From: Dawn Appleton [REDACTED]
Sent: 05 October 2018 12:17
To: Simon Davis
Subject: RE: AW/198/18/PL

AW/198/18/PL

The proposed dwelling is located within the Craigweil House Conservation Area.

DRAWING TITLE
Site Plan, Block Plan and Location Plan

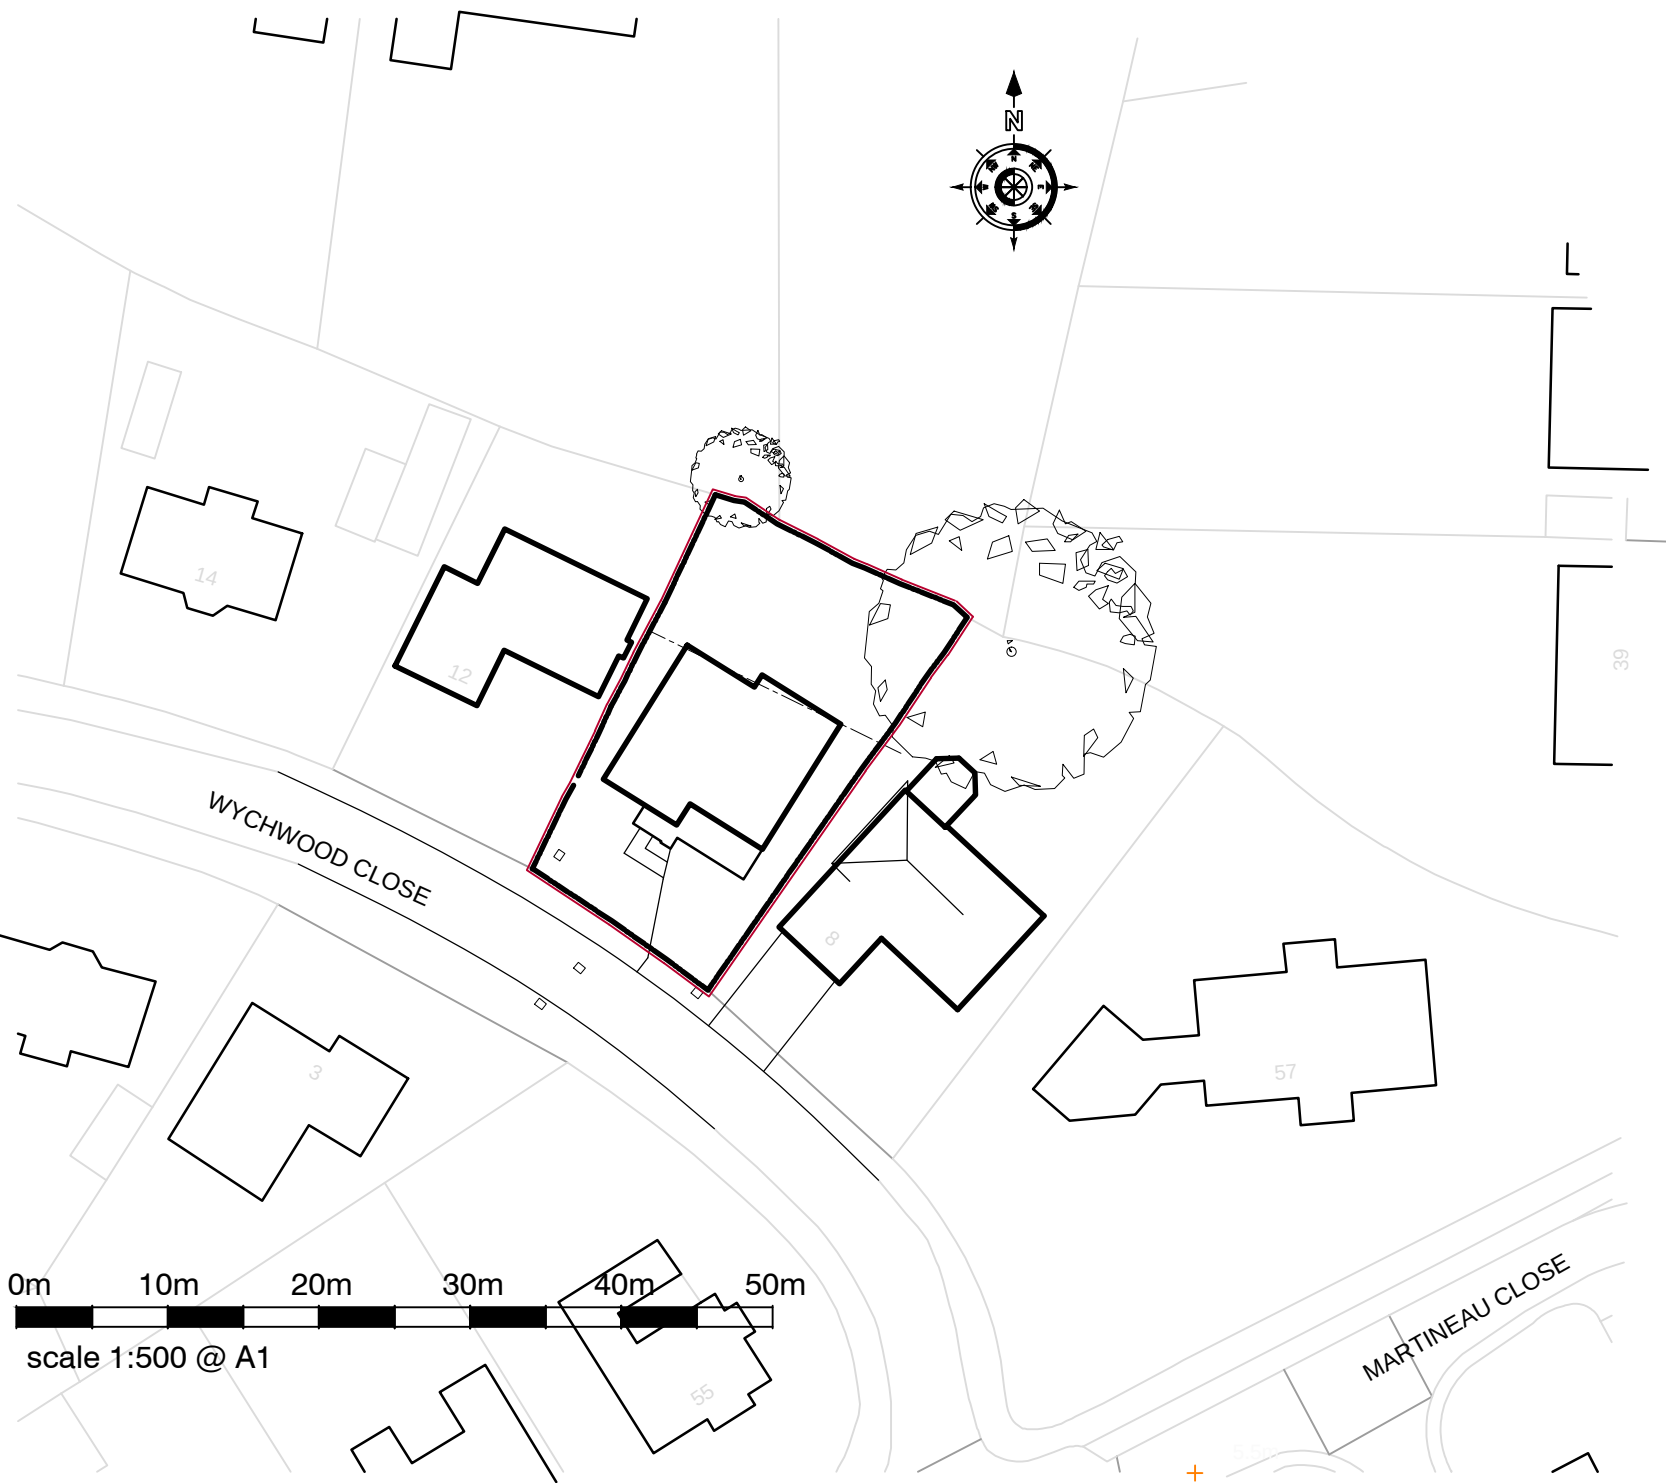
The application also includes a cross over from the highway to the site, and details regarding the paving materials to be used should be provided.

Yes I was intending on submitting a full schedule of materials to avoid a condition. I will get this to you next week.

DRAWING TITLE
Proposed Plans and Elevations

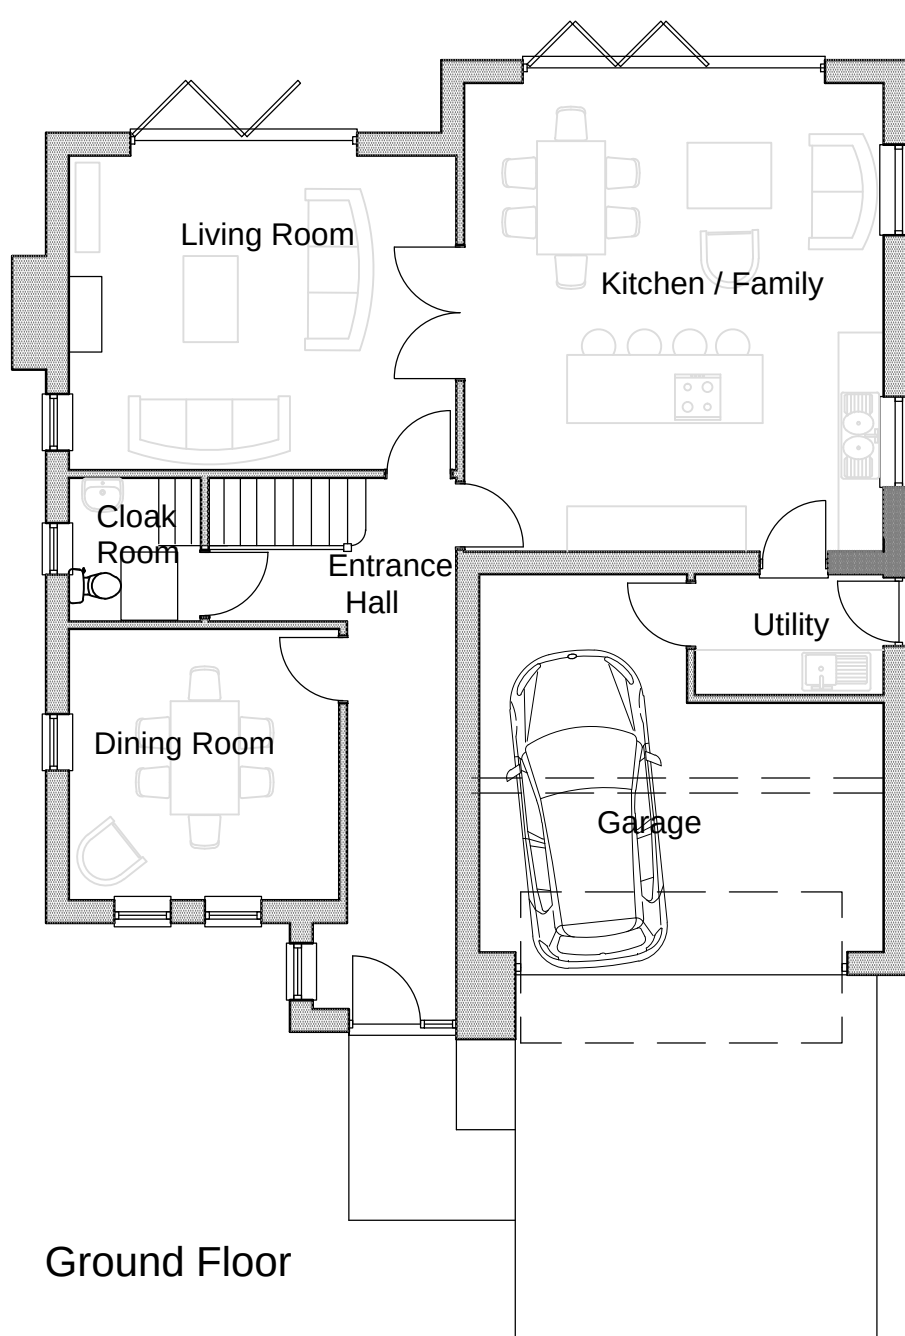
I do have some concerns regarding the use of Cedar boarding, but this may be acceptable depending on the colour/appearance proposed. Maybe this can be confirmed?
